REQUEST

Current Zoning: B-2(CD) (general business, conditional)
Proposed Zoning: B-2(CD) SPA (general business, conditional, site plan amendment)

The petition proposes to amend a previously approved rezoning plan (2017-182) to allow the previously approved carwash as a principle use in an alternate location on the site.

SHHEET NUMBER
RZ-100

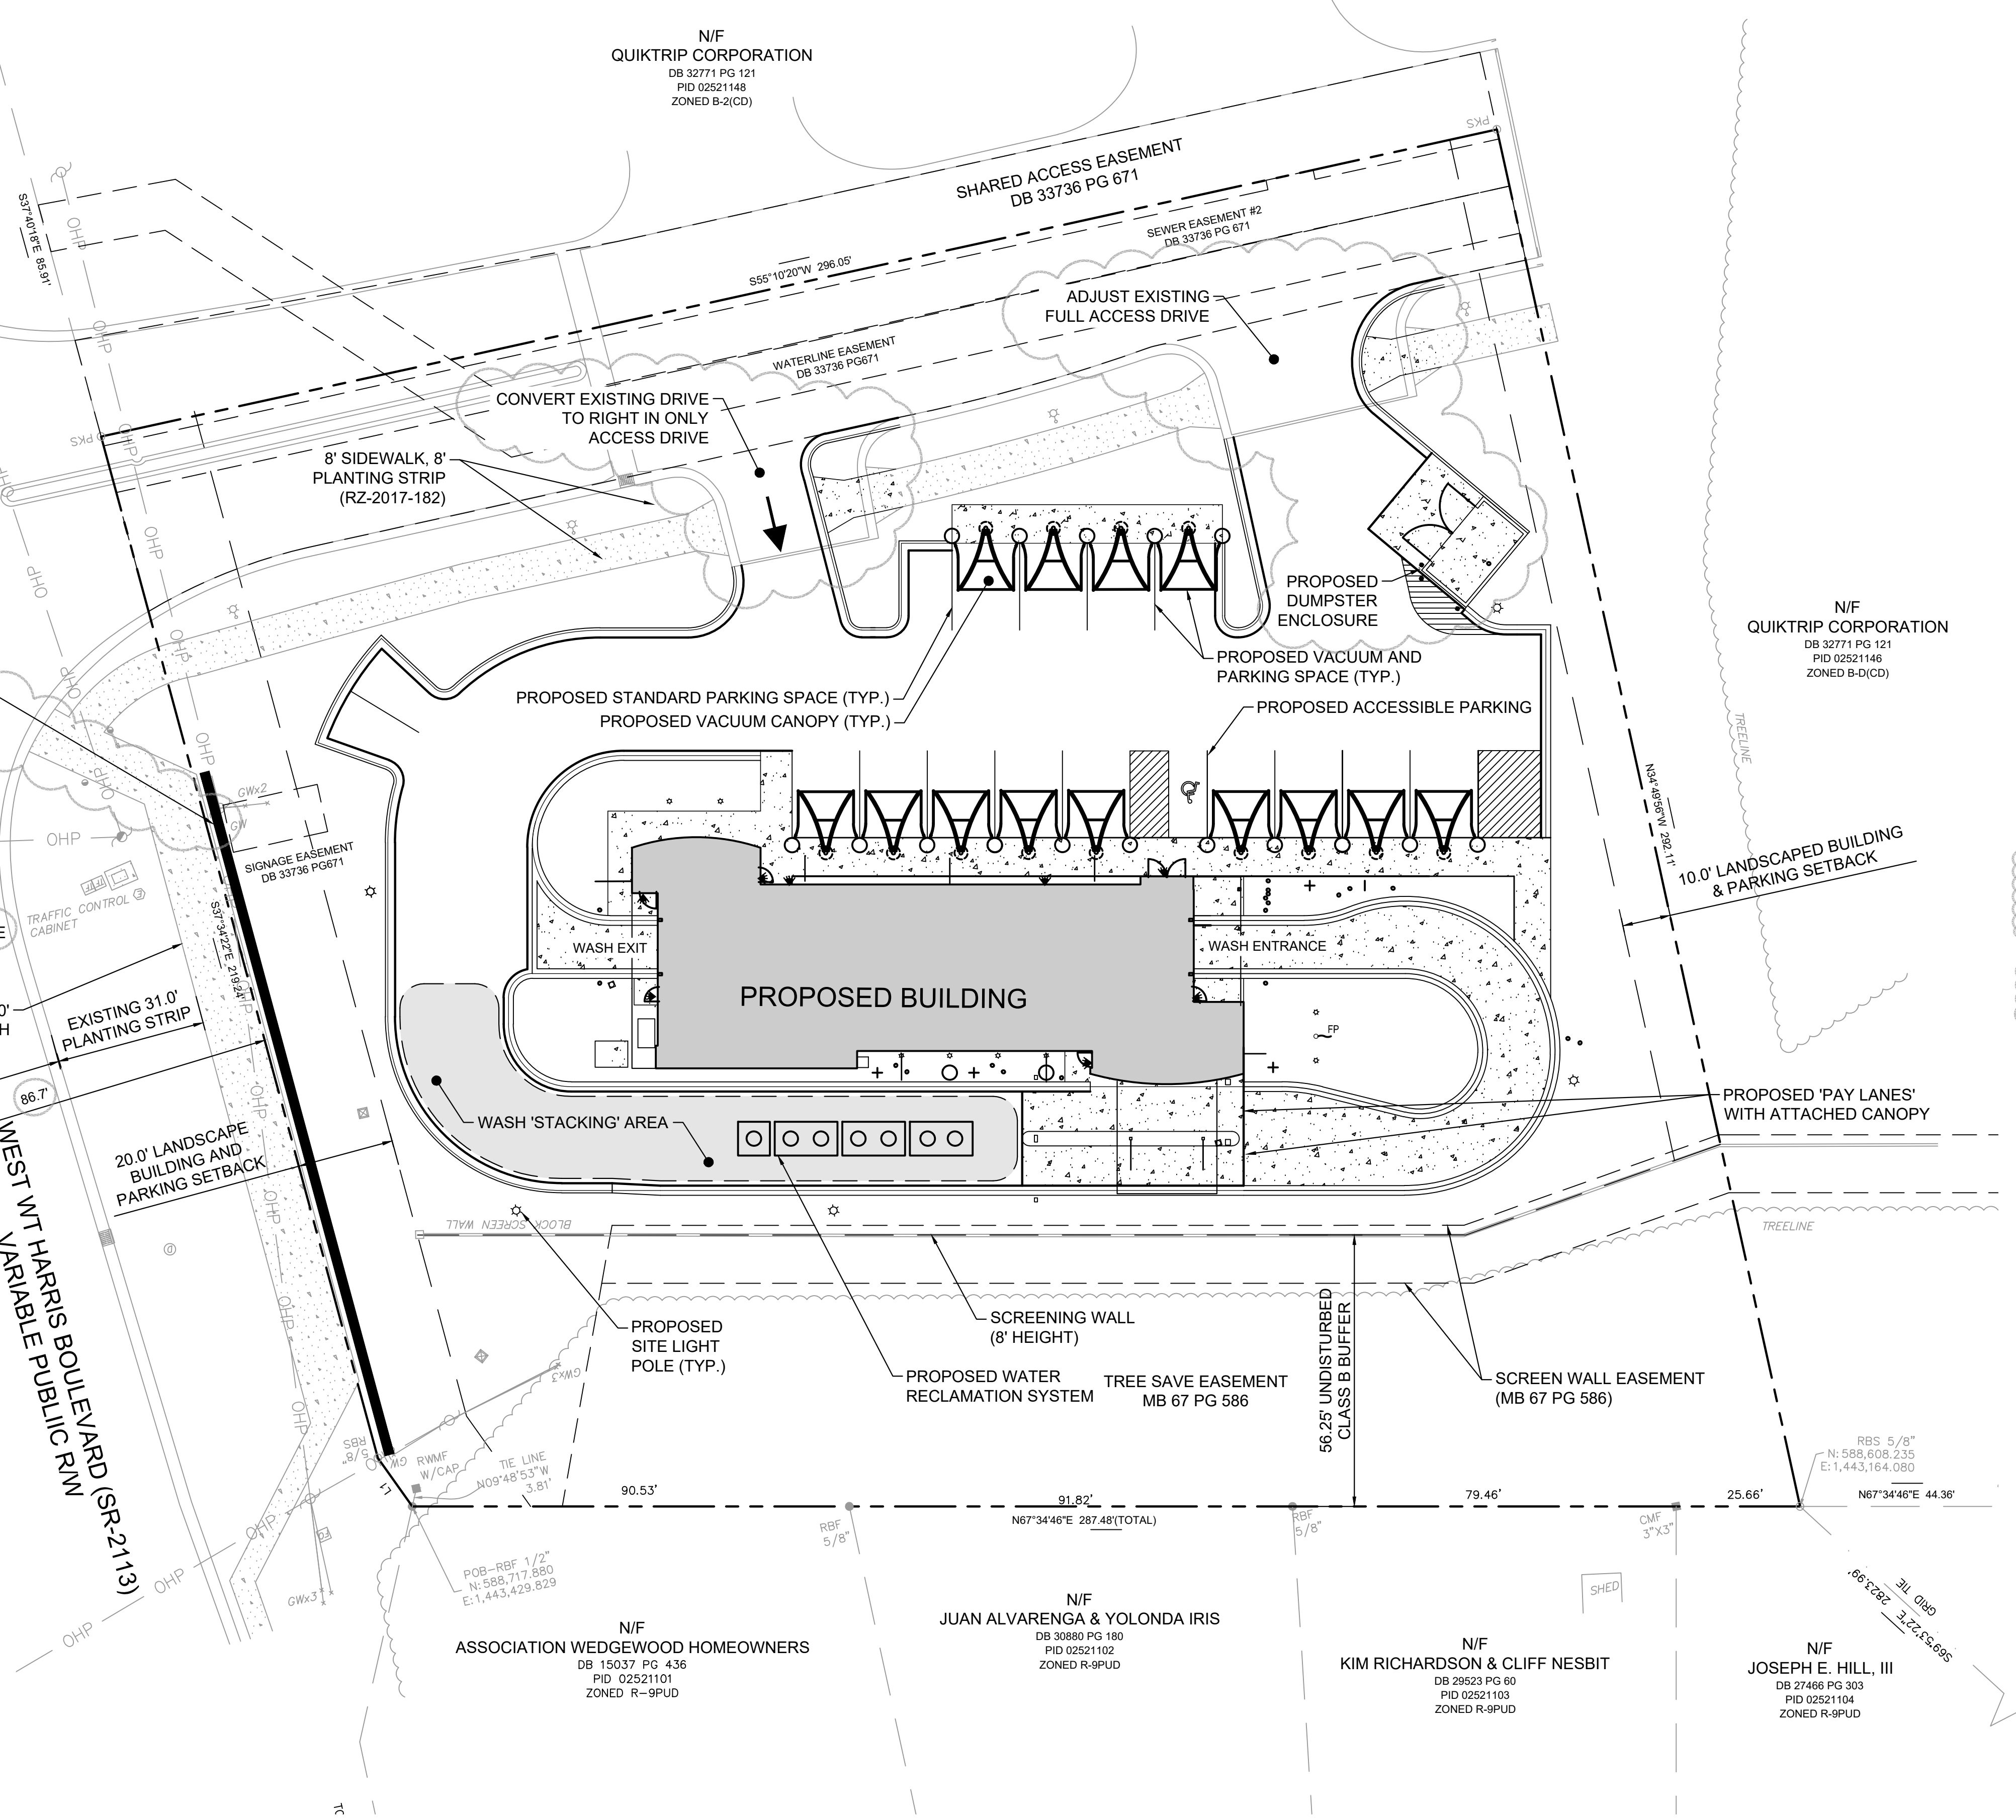
2. ~~Revise the site plan and conditional note(s) to incorporate the minor conditional note corrections below.~~
Addressed

b. THE PLACEMENT AND CONFIGURATION OF THE VEHICULAR ACCESS POINTS ARE SUBJECT TO ANY REGULATIONS REQUIRED TO ACCOMMODATE FINAL SITE DEVELOPMENT AND CONSTRUCTION PLANS AND TO ANY ADJUSTMENTS ~~REQUIRED FOR APPROVAL BY CDOT IN ACCORDANCE WITH APPLICABLE PUBLISHED STANDARDS.~~ **or NCDOT**

c. THE ALIGNMENT OF THE INTERNAL VEHICULAR CIRCULATION AND DRIVEWAYS MAY BE MODIFIED BY THE PETITIONER TO ACCOMMODATE CHANGES IN TRAFFIC VOLUMES, PARKING LAYOUTS AND ANY ADJUSTMENTS REQUIRED FOR APPROVAL BY CDOT IN ACCORDANCE WITH PUBLISHED STANDARDS. **or NCDOT**

d. THE PETITIONER WILL CONSTRUCT REQUIRED ROADWAY IMPROVEMENTS AND PROVIDE ANY REQUIRED SIDEWALK AND UTILITY EASEMENTS NEEDED FOR THESE IMPROVEMENTS PRIOR TO THE ISSUANCE OF THE FIRST CERTIFICATE OF OCCUPANCY, SUBJECT TO THE PETITIONER'S ABILITY TO REQUEST THAT CDOT ALLOW A BOND TO BE FORWARDED TO CDOT TO COVER THE COST OF ANY IMPROVEMENTS NOT FINALIZED AT THE TIME OF THE ISSUANCE OF THE CERTIFICATE OF OCCUPANCY, AS ALLOWED BY **sidewalk utility easement**

e. THE PETITIONER WILL DEDICATE VIA FEE SIMPLE CONVEYANCE ANY REQUIRED RIGHT-OF-WAY INDICATED ON THE REZONING PLAN AS RIGHT-OF-WAY TO BE DEDICATED. THE ADDITIONAL RIGHT-OF-WAY WILL BE DEDICATED PRIOR TO THE ISSUANCE OF THE FIRST CERTIFICATE OF OCCUPANCY. THE PETITIONER WILL PROVIDE A PERMANENT SIDEWALK EASEMENT FOR ANY OF THE PROPOSED SIDEWALKS LOCATED ALONG THE PUBLIC STREETS LOCATED OUTSIDE OF THE RIGHT-OF-WAY. THE PERMANENT SIDEWALK EASEMENT WILL BE LOCATED A MINIMUM OF TWO (2) FEET BEHIND THE SIDEWALK WHERE FEASIBLE.

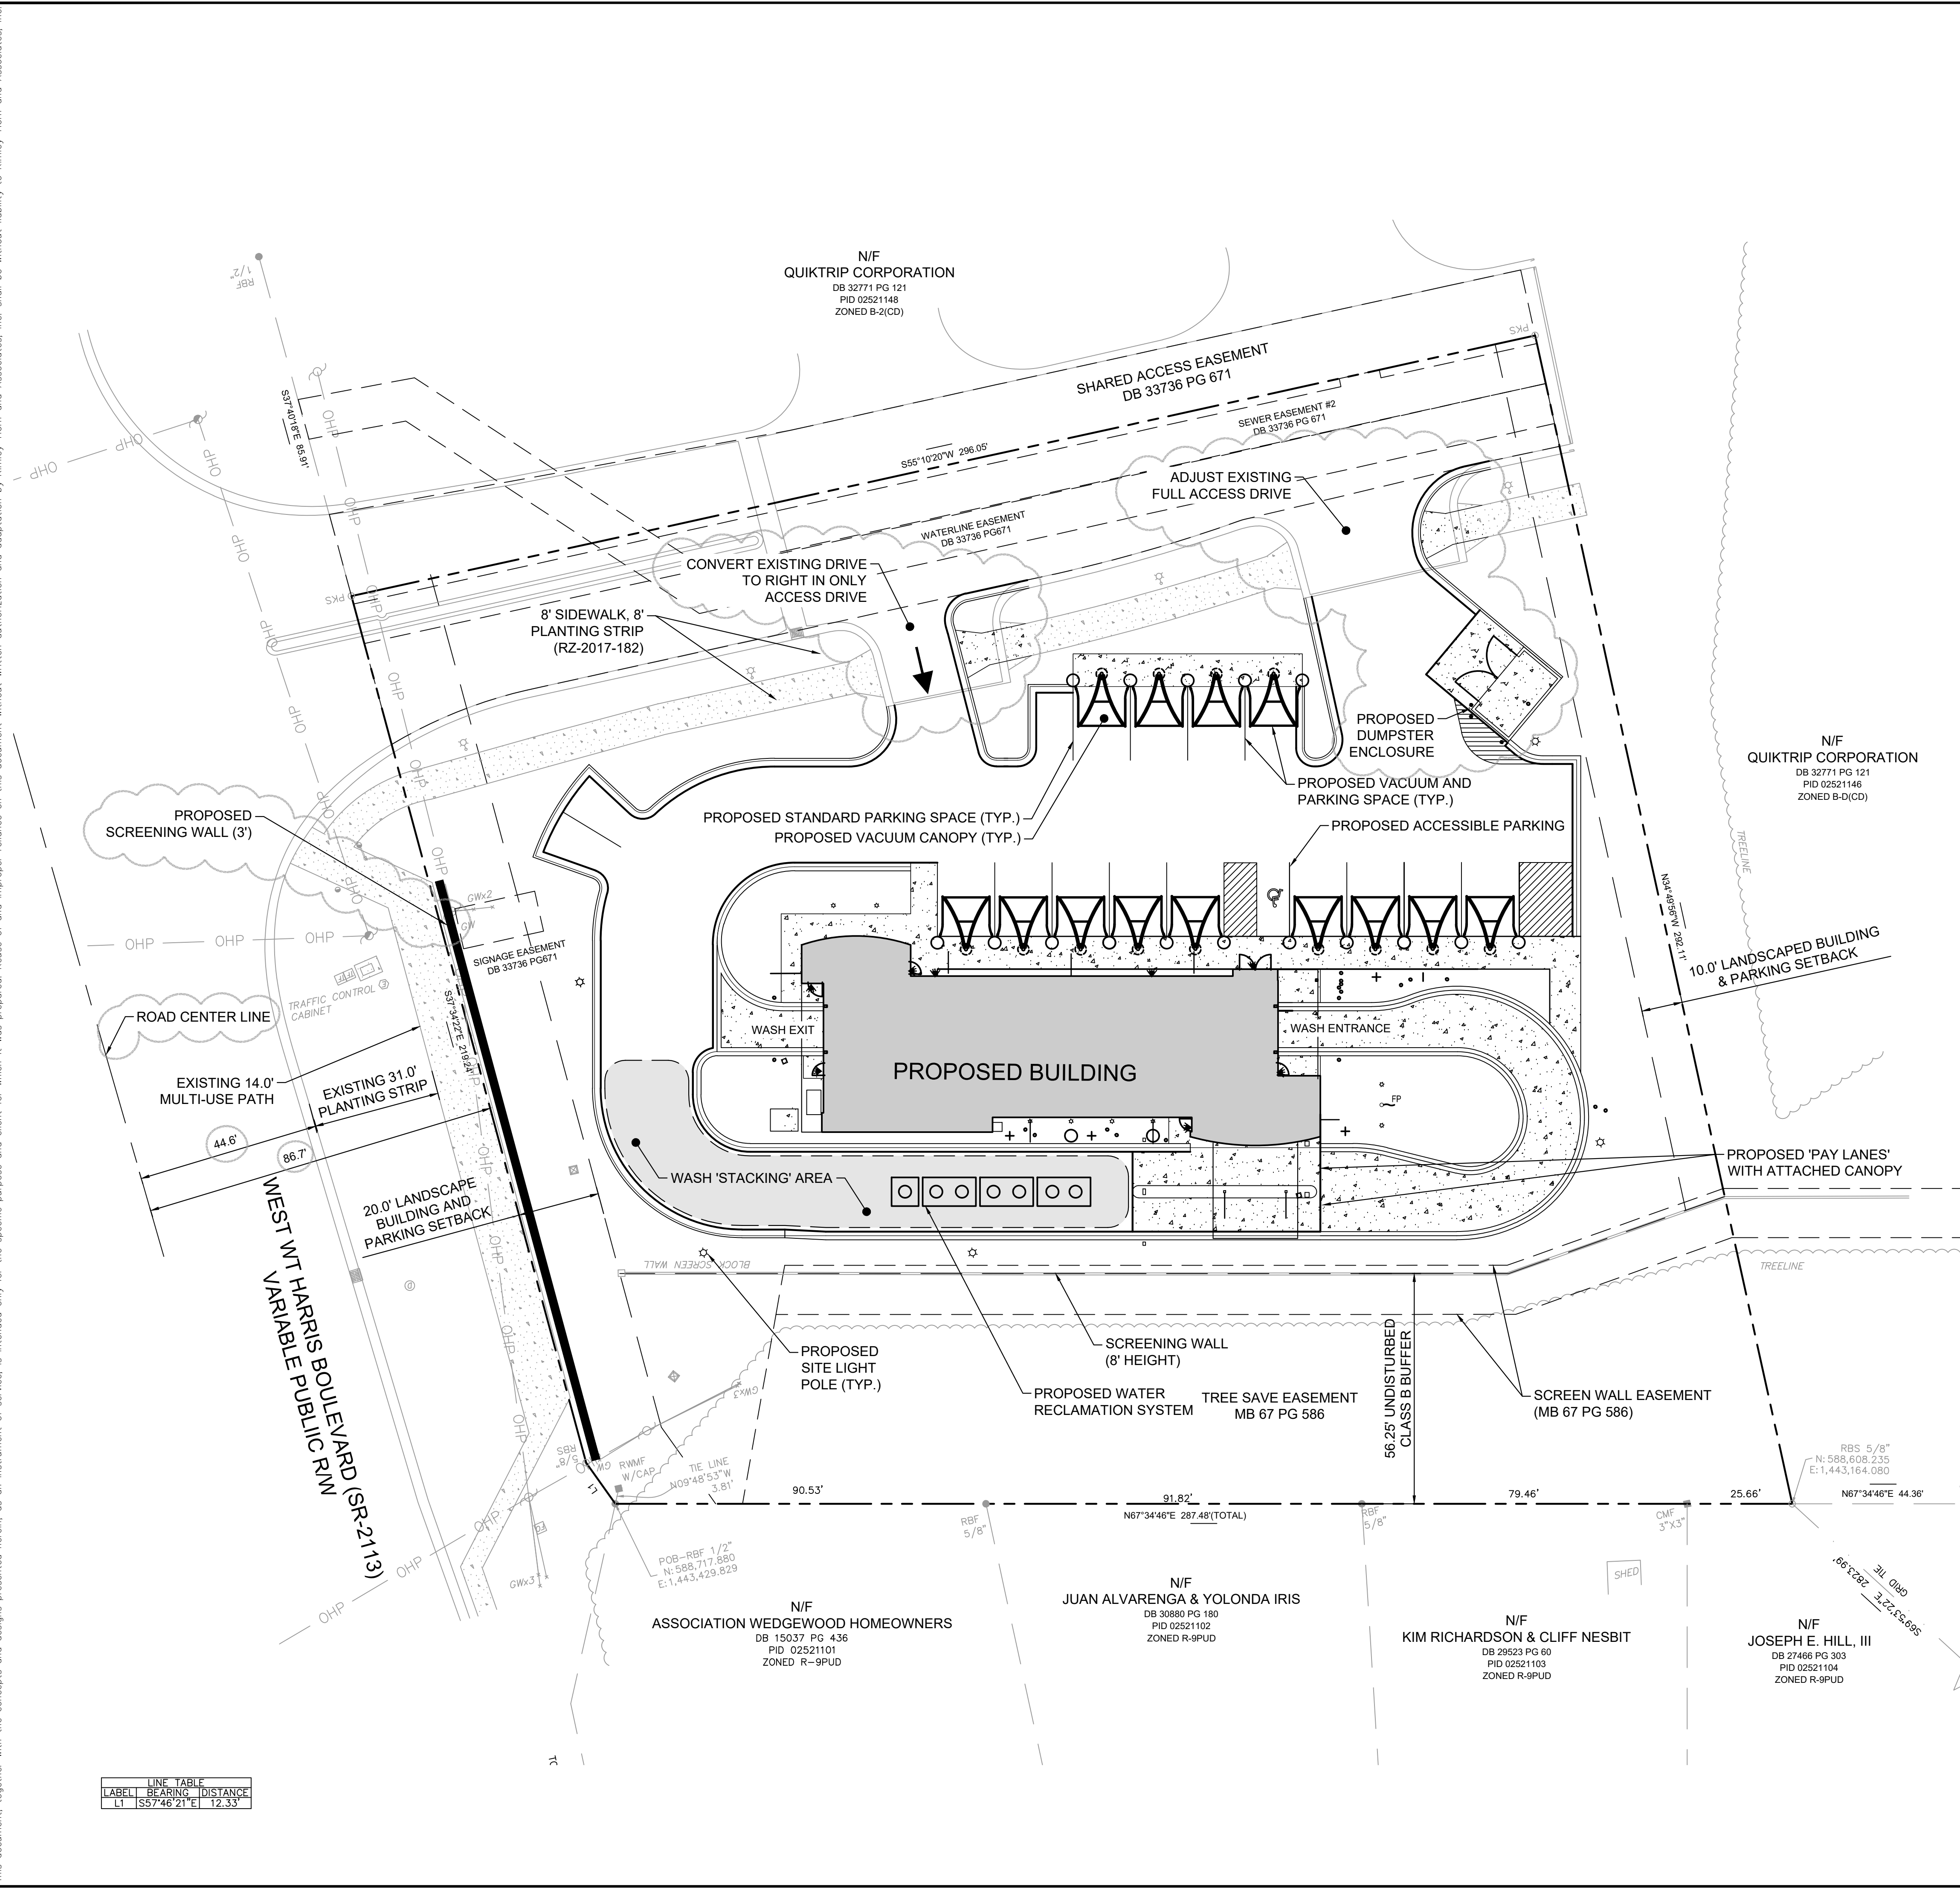
1. ~~Either remove the right in only driveway and keep the full access drive or keep the right in only access driveway and convert the full access drive to egress only. Revise conditional note 2f. to update this language to match the revised driveway design.~~ Addressed
